3 April 2019

SCEGGS Darlinghurst Concept and Stage 1 DA

Figure 1 – Proposed Amendments to Wilkinson house

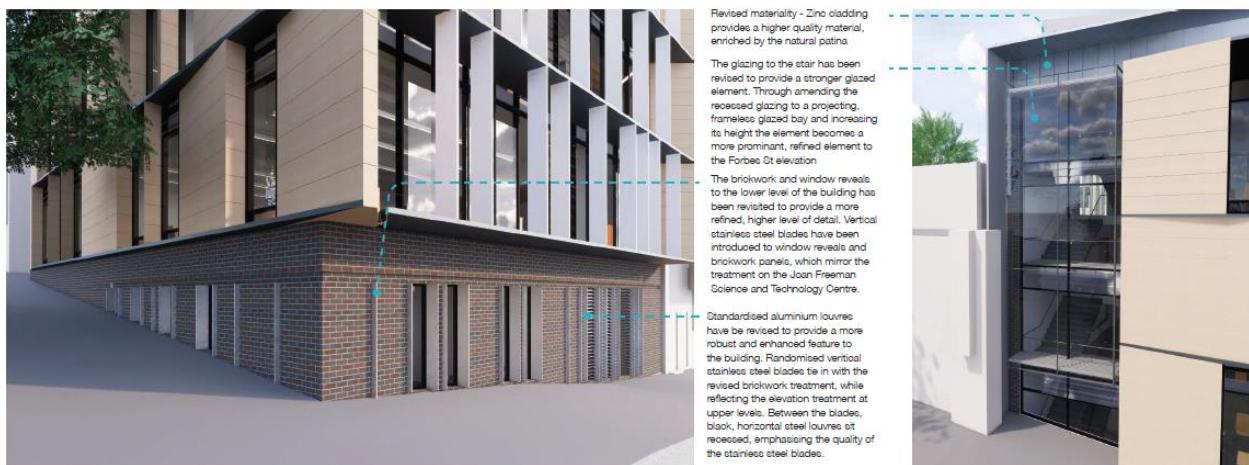
I share widespread community concern that the concept plan proposes to demolish the heritage significant Wilkinson House.

Of great concern is that the proposed replacement building in Wilkinson House's current location is ordinary and would detract from the streetscape.

The environmental impact statement fails to provide adequate justification for the demolition of this significant building. The school should retain Wilkinson House's façade at the very least while renovating the interiors for adapted reuse.

Demolition of Wilkinson House must be rejected.

Figure 4 – Proposed Building Envelope Amendments to the Multi-purpose building

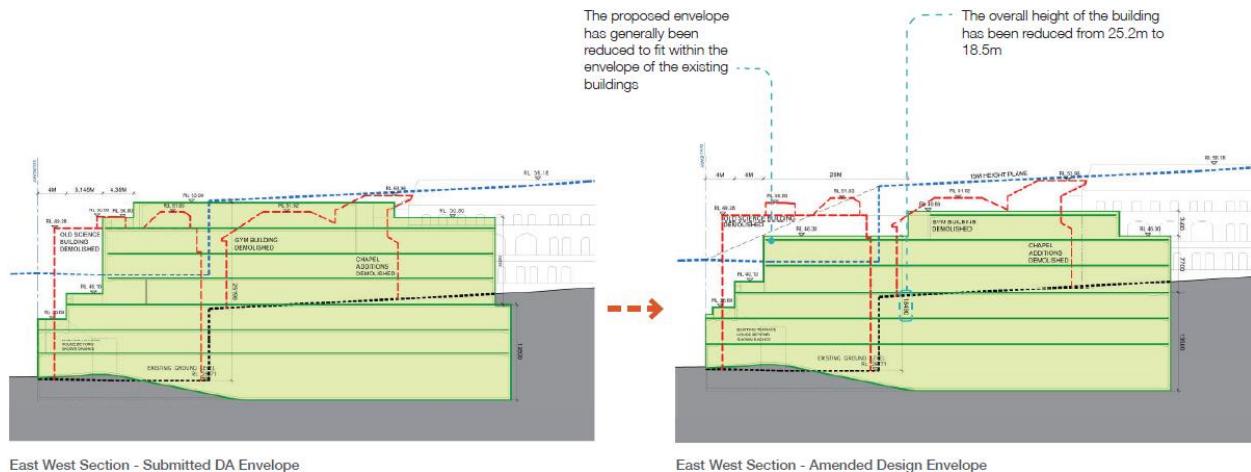
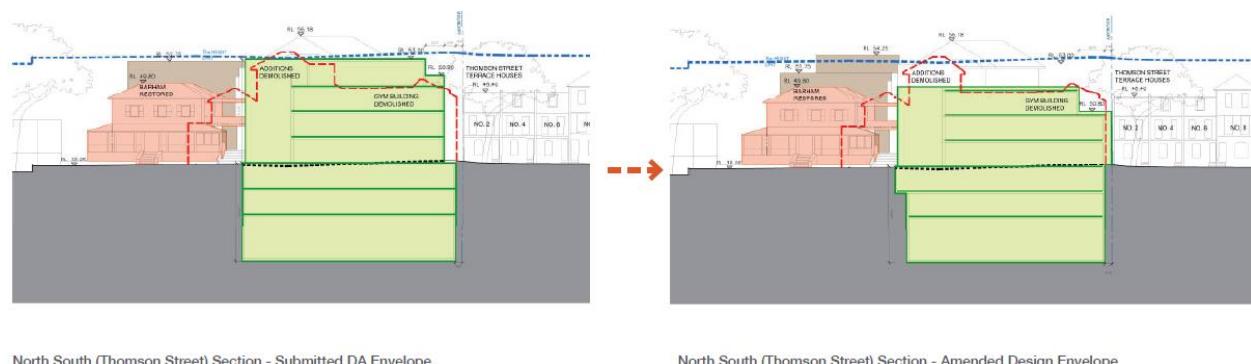
The proposed Multipurpose Building is almost three metres higher than existing buildings it will replace, putting it out of scale with the local area, impacting on Thomson Street residents' homes through overshadowing during winter and interrupting existing views of the city and water from homes and the public domain.

SCEGGS Darlinghurst should be a good neighbour and amend proposals through setbacks and/or reduced heights to ensure winter sunlight is not obliterated in adjacent homes.

Figure 10 – Thomson Street Winter Solstice Overshadowing Impacts

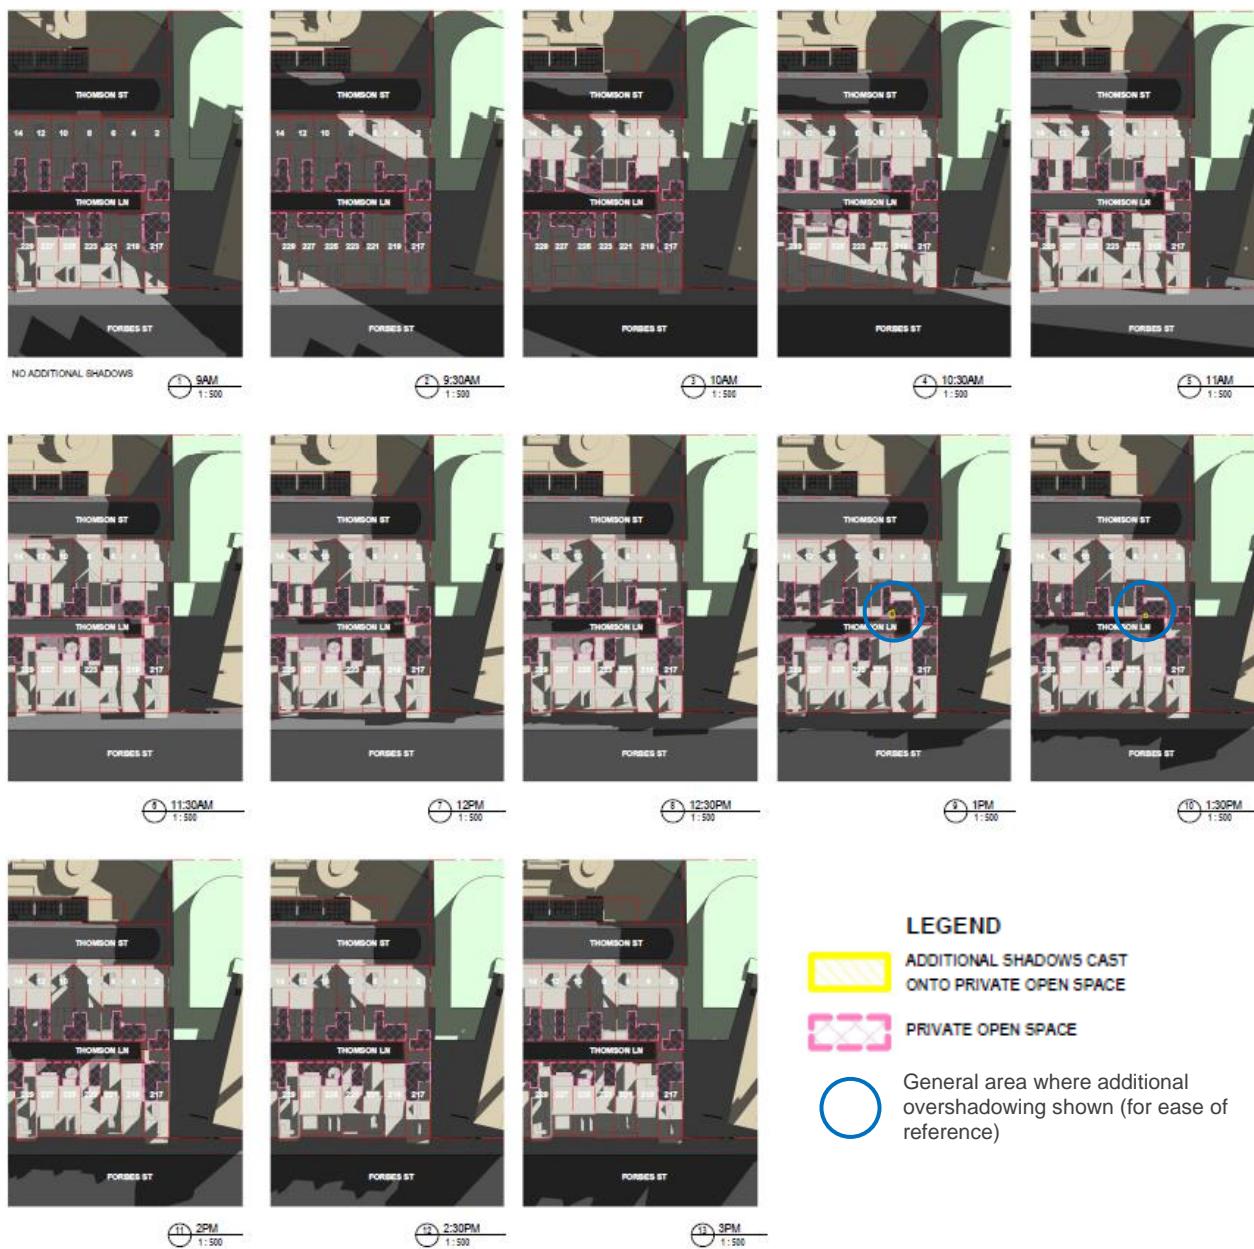
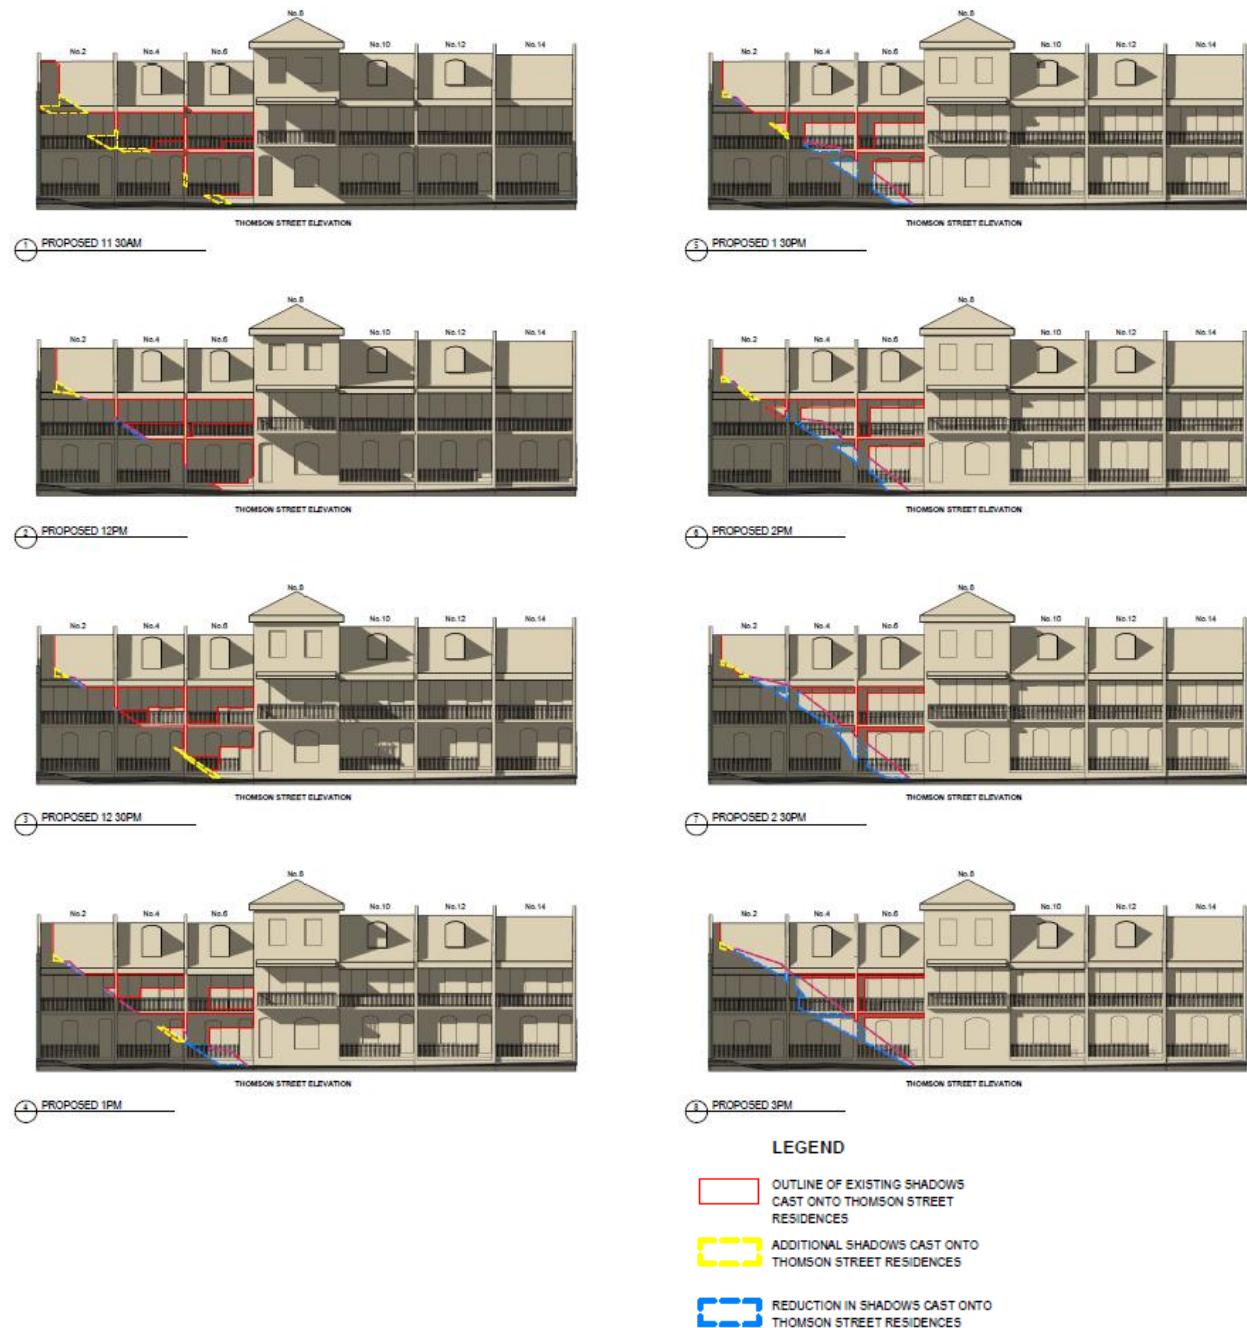
Terraces at 2, 4, 6 and 8 Thomson Street will suffer significant and unacceptable loss of sunlight in their homes during winter, with impacts felt throughout the day. Sunlight is essential to residents' quality of life and can reduce the need for heating and lighting, help plants grow, and reduce dampness and mould.
